Application number: 2026/90136	
What is the application for?:	Erection of first floor side extension (within a Conservation Area)
Address of the site or building:	153, West End, Netherthong, Holmfirth, HD9 3EJ
Postcode:

Type of comment: An objection	
Do you wish your comments to be published on the website anonymously?	Yes
Thank you for the chance to follow up on my previous comments. I write again to strongly object to the above planning application based on the following material planning considerations: 1. Failure to Meet Design Standards and Loss of Symmetry (Policy LP24) While the applicant claims the design seeks to "preserve symmetry", the proposal results in a complete loss of any remaining architectural balance. By adding a first-floor extension of this scale, the original proportions of the dwelling are compromised. Under Kirklees Local Plan Policy LP24(a) and the House Extensions SPD, alterations must respect the form and character of the host building. This proposal creates an unbalanced, top-heavy appearance that is over-dominant and fails to remain a "subordinate" element. 2. Harm to the Setting of the Grade II Listed All Saints' Church (Policy LP35) Under Policy LP3

| Description<br><br>PROPOSED PLANS                                                                                                                                                                                                      |             |          |               |      |

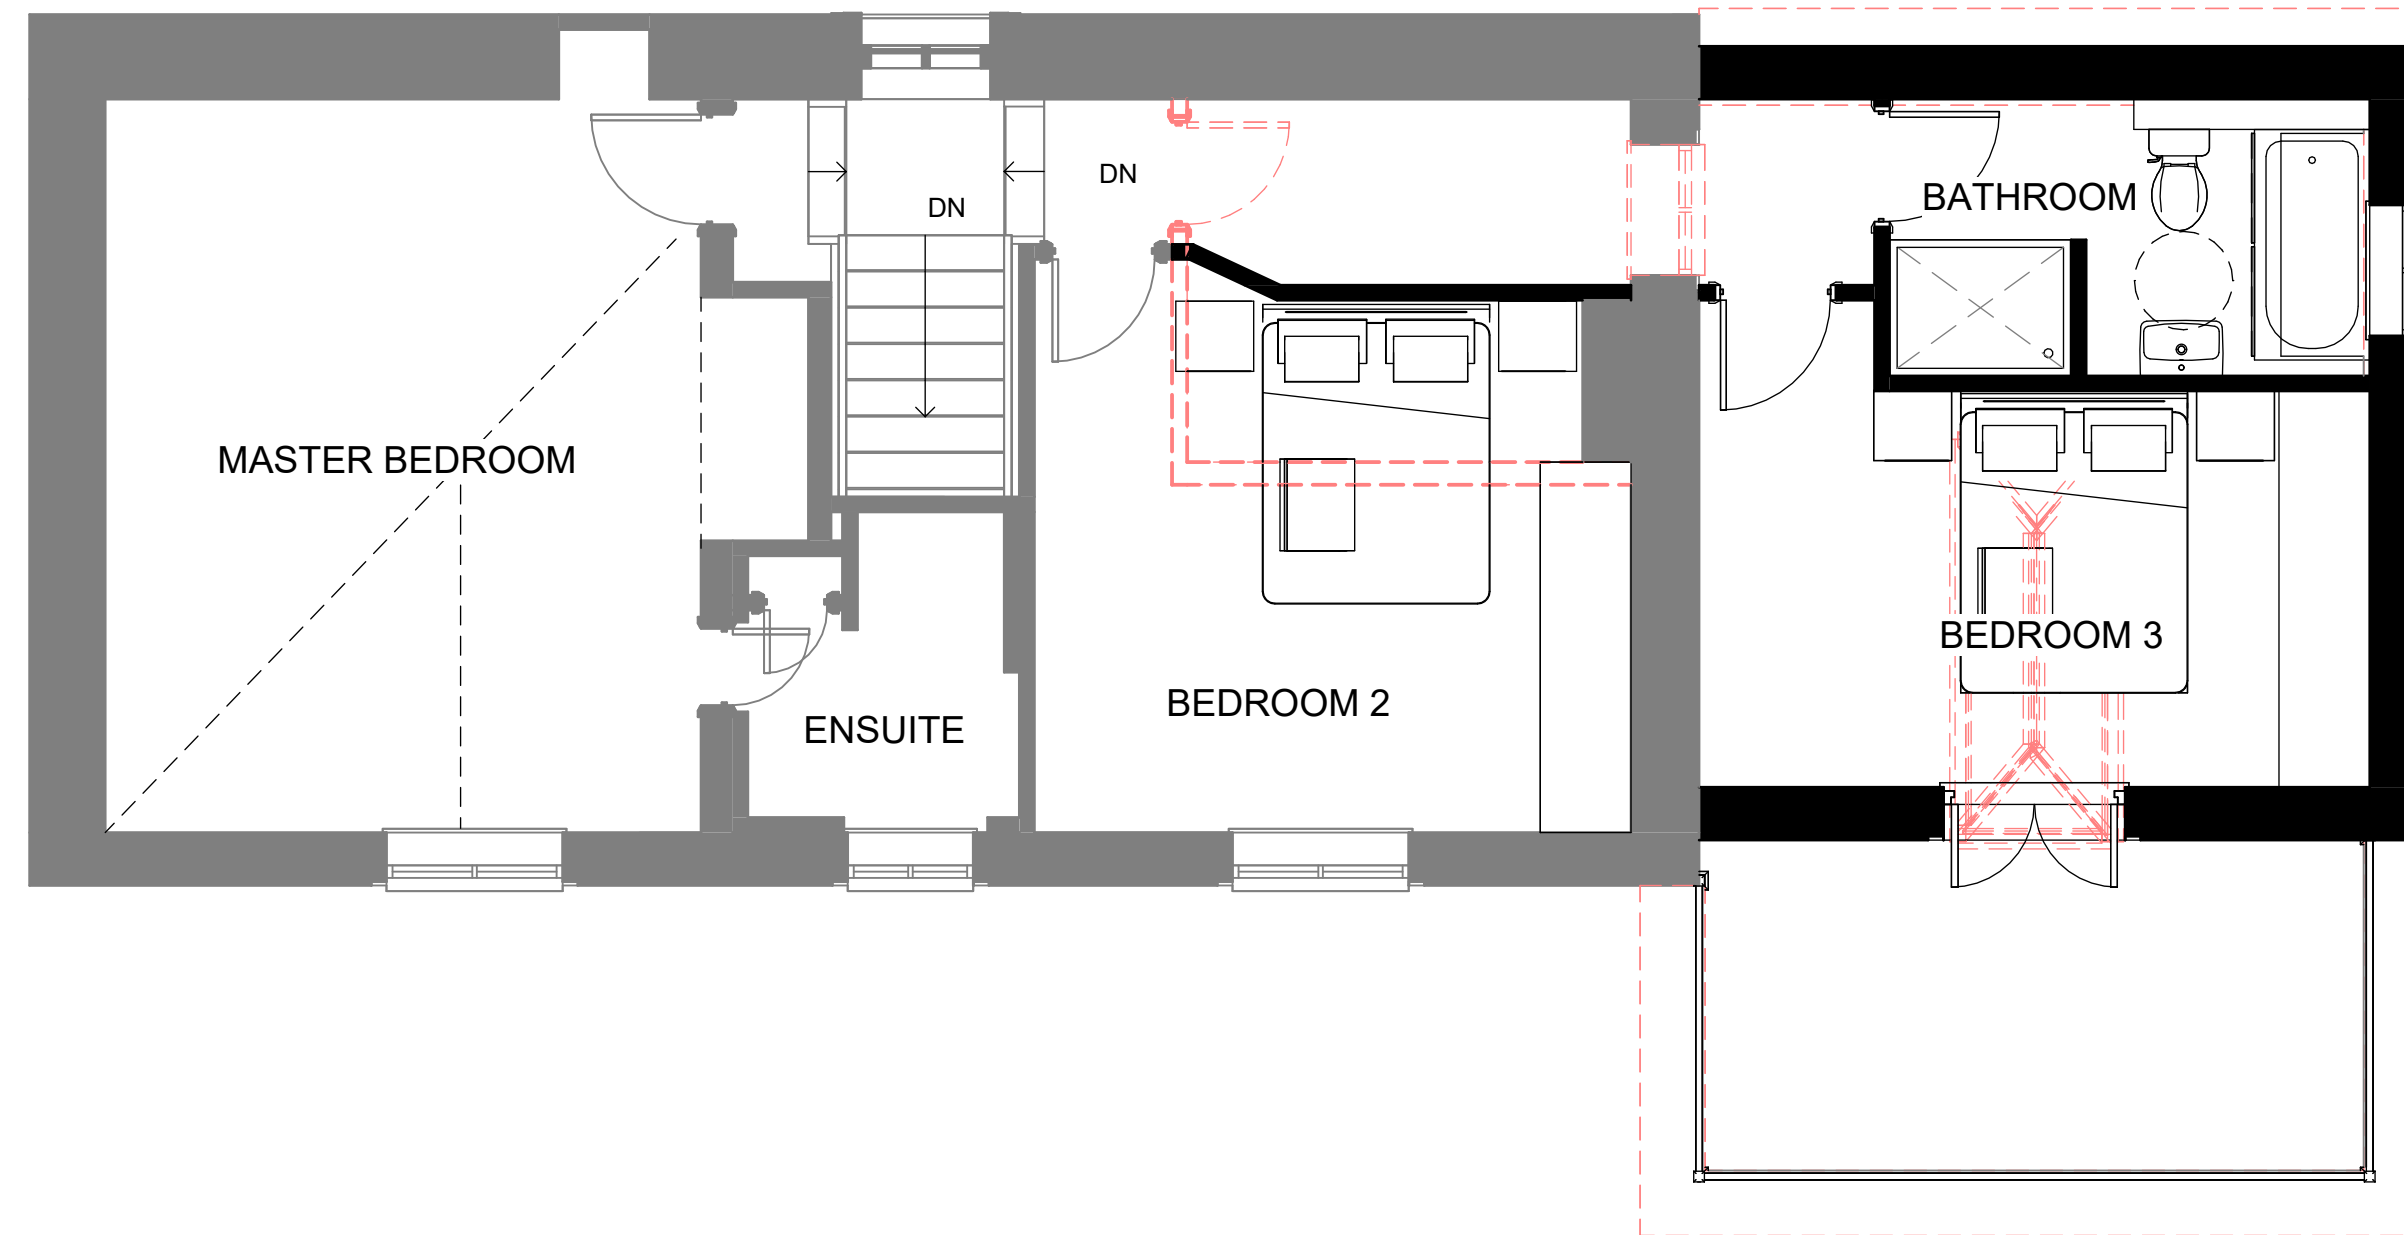
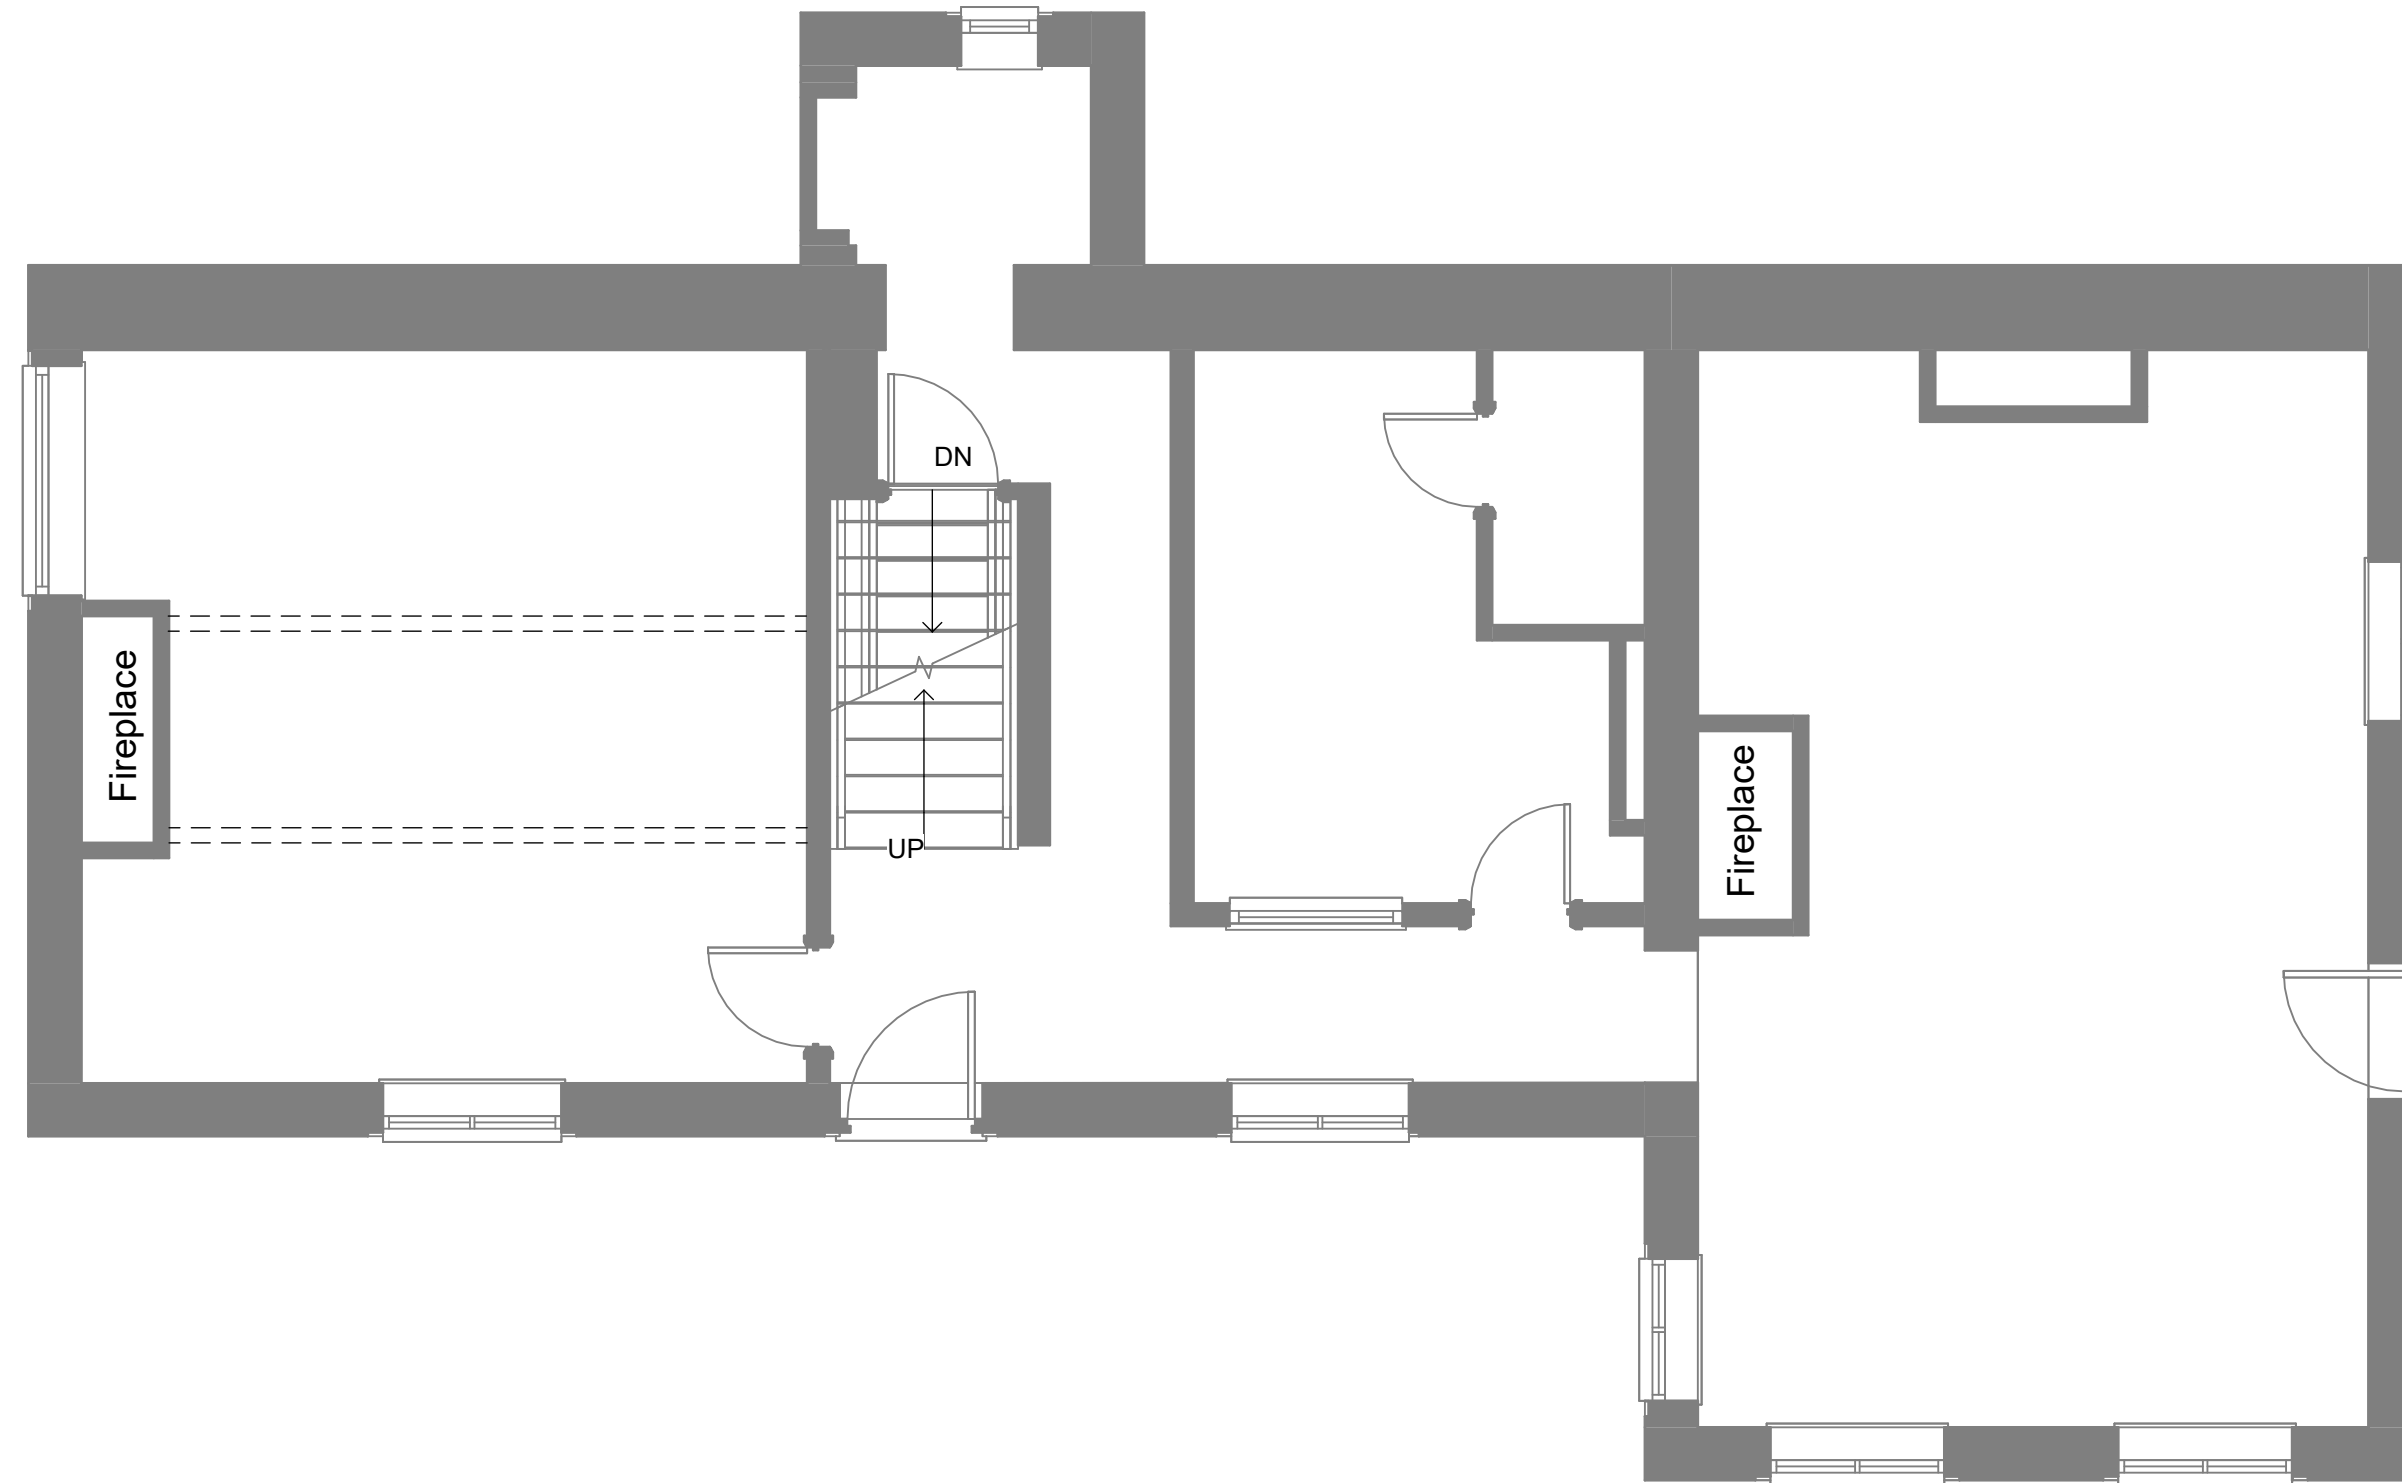
Principle 5 of the Kirklees House Extensions SPD, which states that extensions will not be permitted if they unreasonably overshadow neighbouring properties. I urge the case officer to apply the 45-degree rule to this elevation, as the drawing indicates a material loss of natural light presently enjoyed by the occupants of 153a.

The proposal represents an overdevelopment of the site that is contrary to the Kirklees Local Plan and the House Extensions SPD. I respectfully request that the Planning Officer conducts a site visit to view the impact from the neighbouring properties and the churchyard, and ultimately refuses the application.
